From: Laura Gibbons
Sent: 16 November 2021 14:25
To: Maria Tomalova
Subject: FW: Y/139/21/DOC The Green House Sussex Ltd. Lake Lane, Barnham
Attachments: 5877_Updated-to-watercourse-DR10 (A1) 6215.pdf; 5877_Updated-to-watercourse-DR11 (A1) 6215.pdf; 5877 no discharge..pdf; 5877 ordinary_watercourse_application_form[2].pdf

6215 - DR10

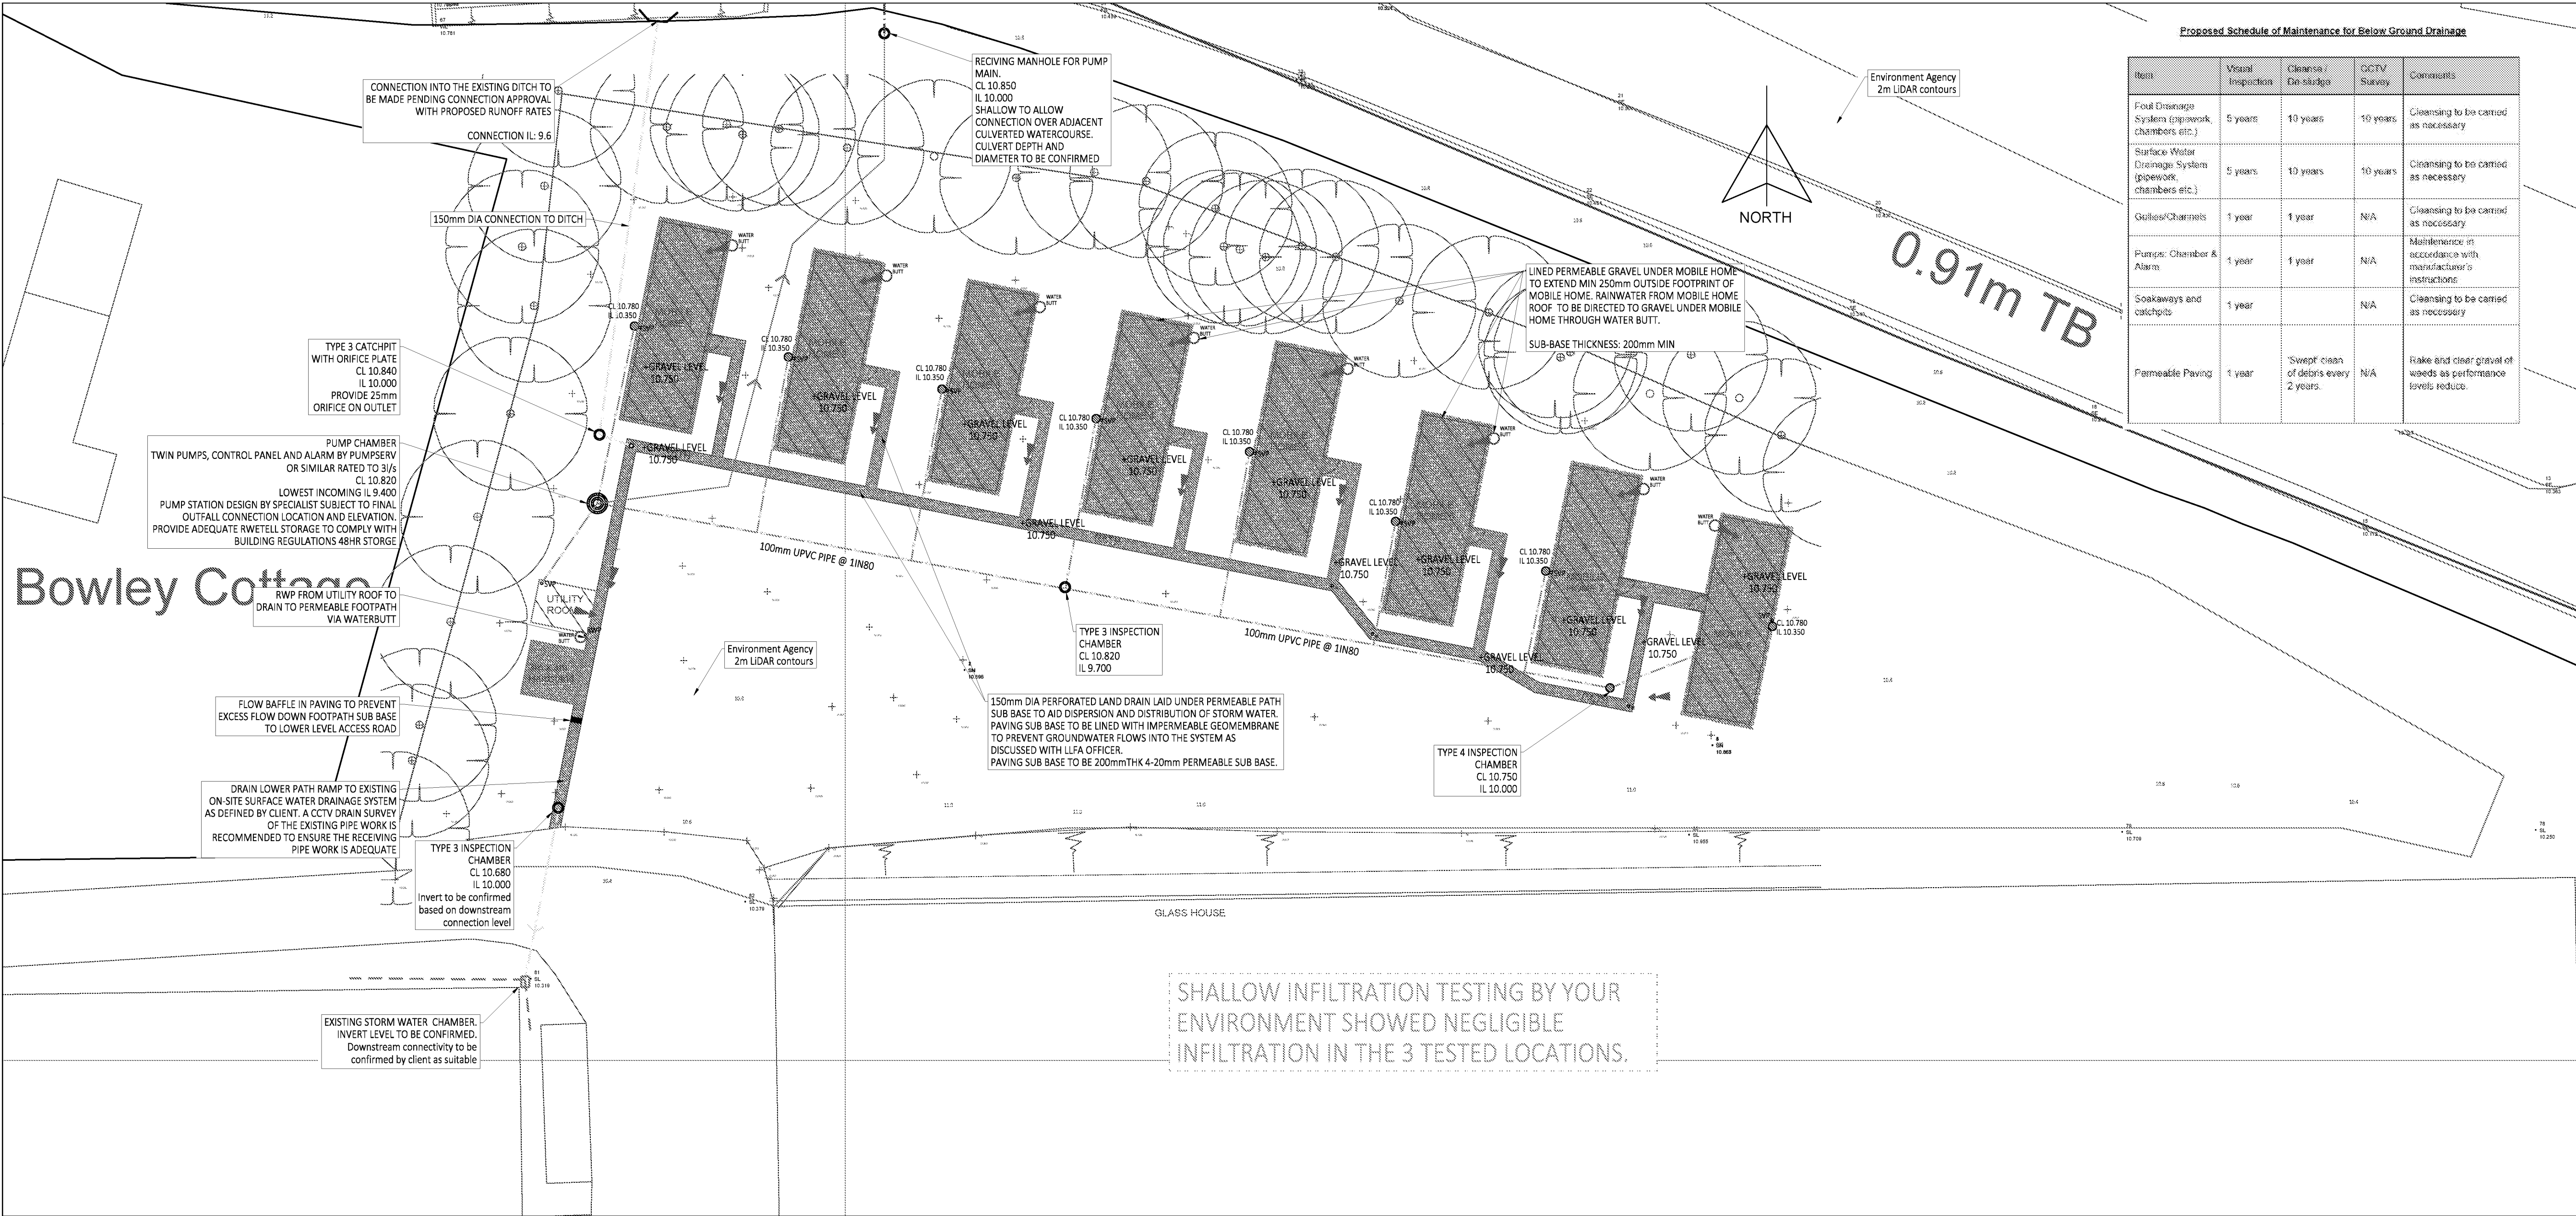
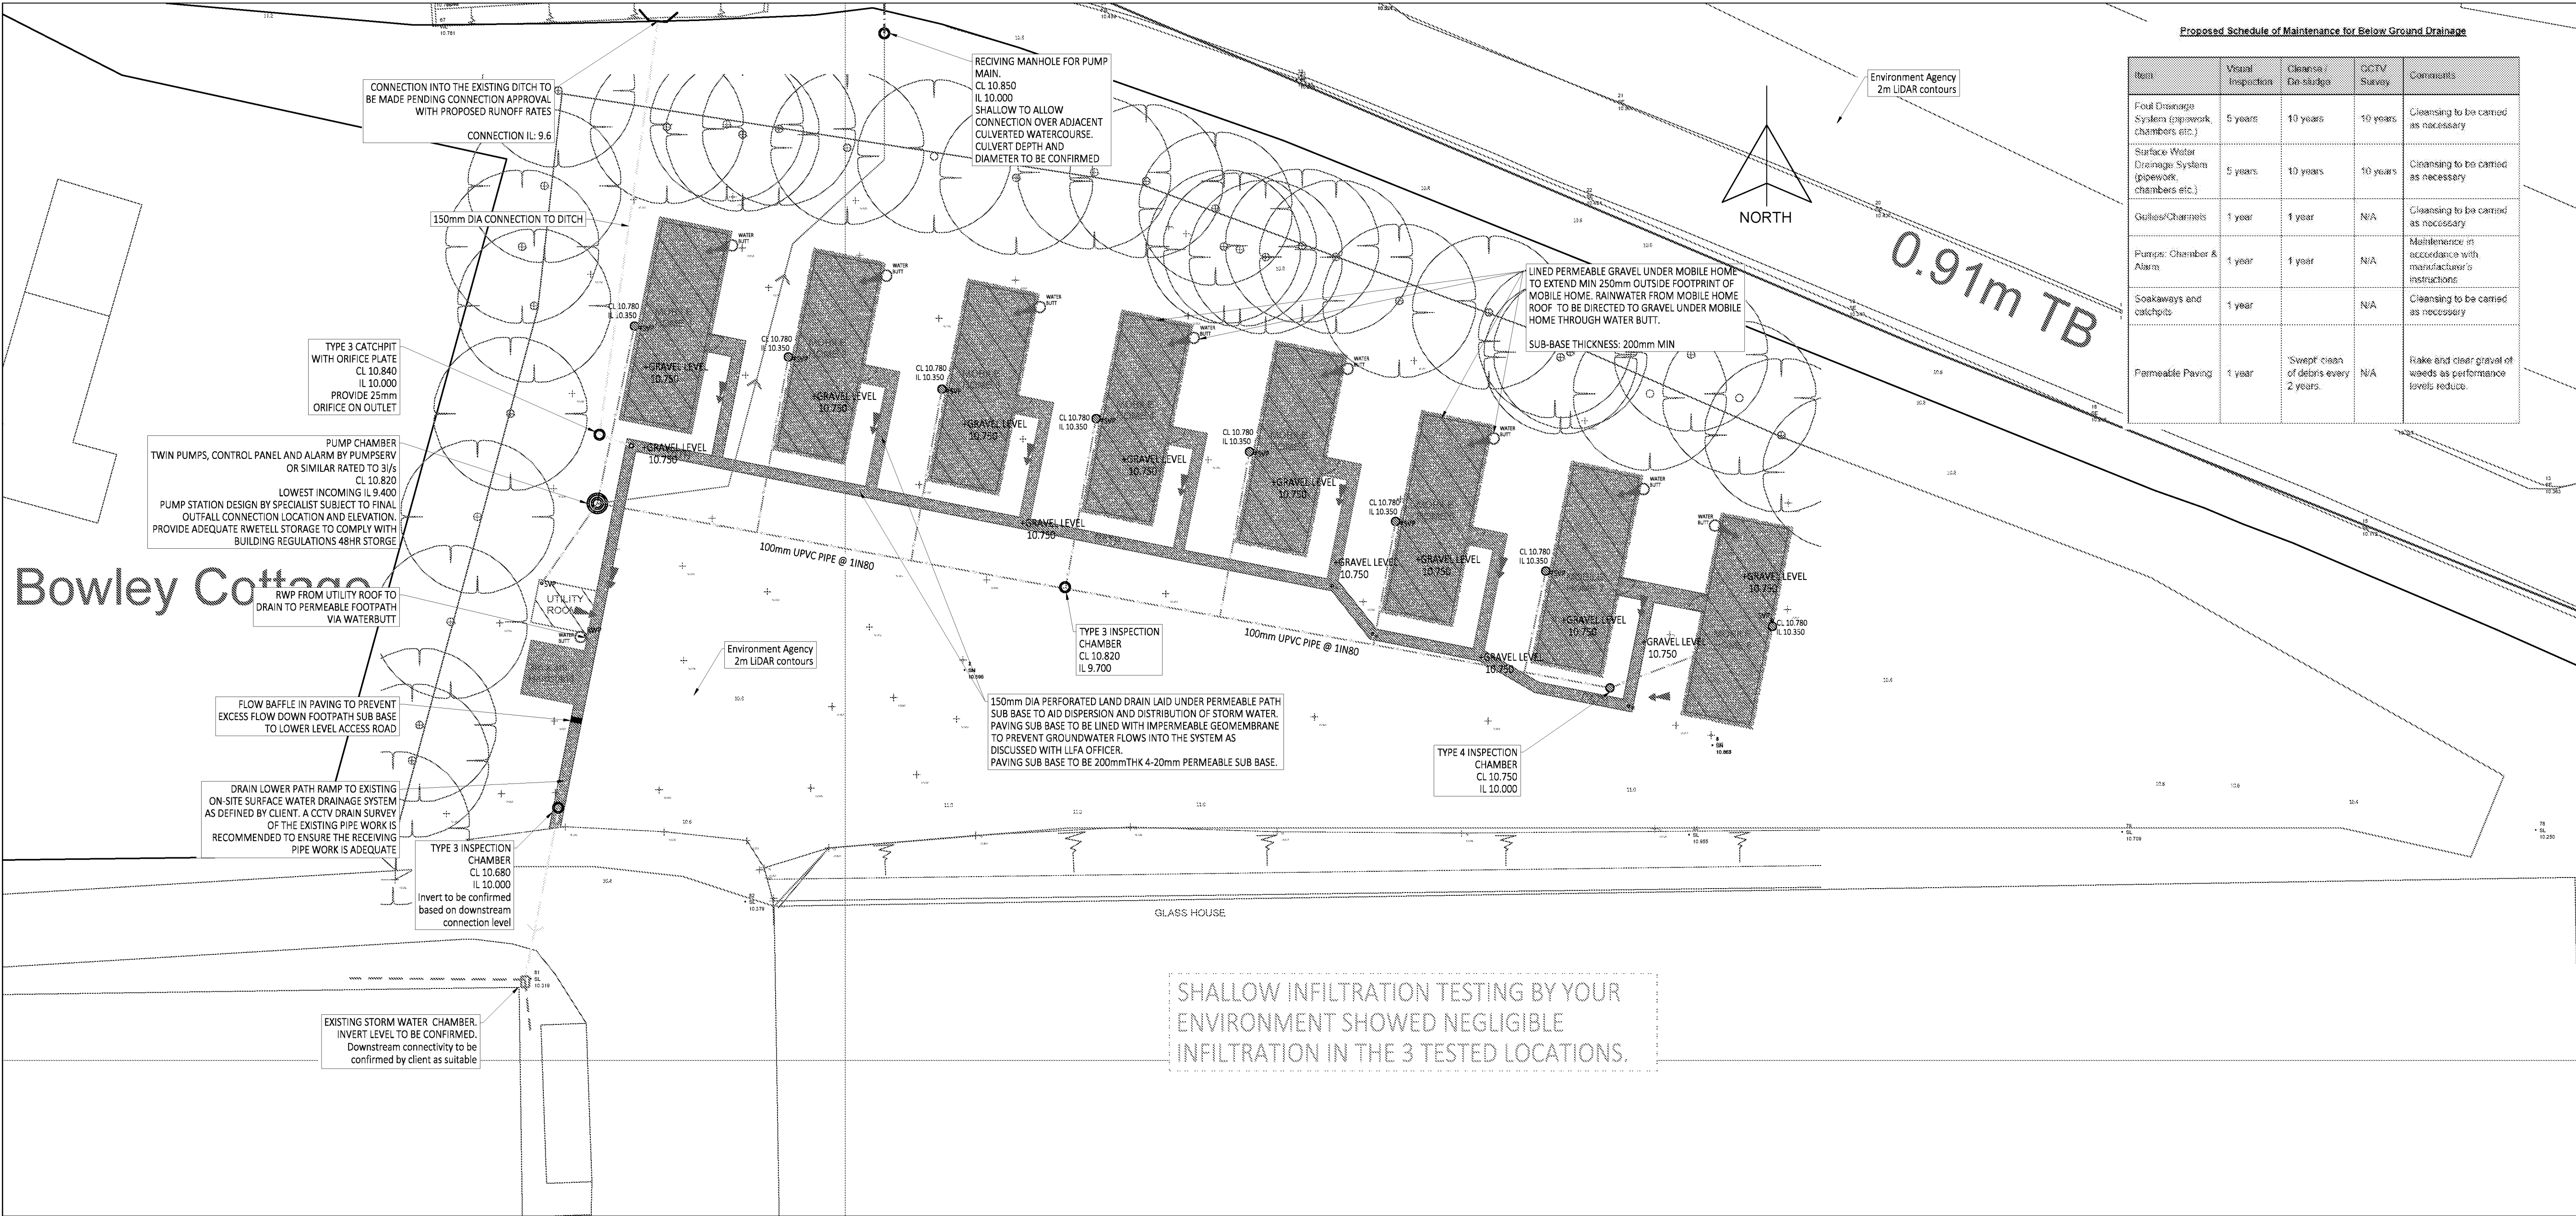
- The headwall drawings should show the setting of the headwall, i.e. include bed and bank, and bank profile.
- The sub-base depth under the caravans is still stated as 200mm.
- As an absolute minimum a land drainage consent application should be submitted prior to determination of this application.

1. As it is proposed to include a perforated carrier pipe in/below the subbase it is not necessary to include a fall on the subbase. We will make it clearer on the layout drawing that it is proposed to have a perforated pipe.

3. The 25mm orifice is OK as it is downstream of permeable paving that will have a 20mm void which will mitigate the risk of blockage of the outfall
4. All surface water pipes must be labelled with diameter and fall. A clear note will be included that all pipes will be 150mm dia and laid at a gradient of 1:100.

6. A concrete bed and surround will be provided where the pipes go through the trees.
7. The construction details for the flow control device and outfall will be updated to include the site specific cover and invert levels.

- The headwall details are no[t] site specific. Please see attached drawing(s) to clarify.
- There are two flow control construction details, please remove the detail which is not site specific. Please see attached drawing(s) which have been updated to confirm site specific detail. The additional details has also been removed.
- The no discharge calculations show that there is insufficient storage. Currently proposals are for a 200mm thick sub-base, this would provide approximately 30m³ of storage, the calculations show a required storage volume of 67.7m³. Please see attached drawing(s) which confirms subbase depth has been increased to 500mm (note underlined for clarity).
- Please supply evidence of land drainage consent. Please see attached a copy of the Land Drainage Consent Application Form, to be finalised and submitted once confirmation is received Condition 5&6 can be discharged..
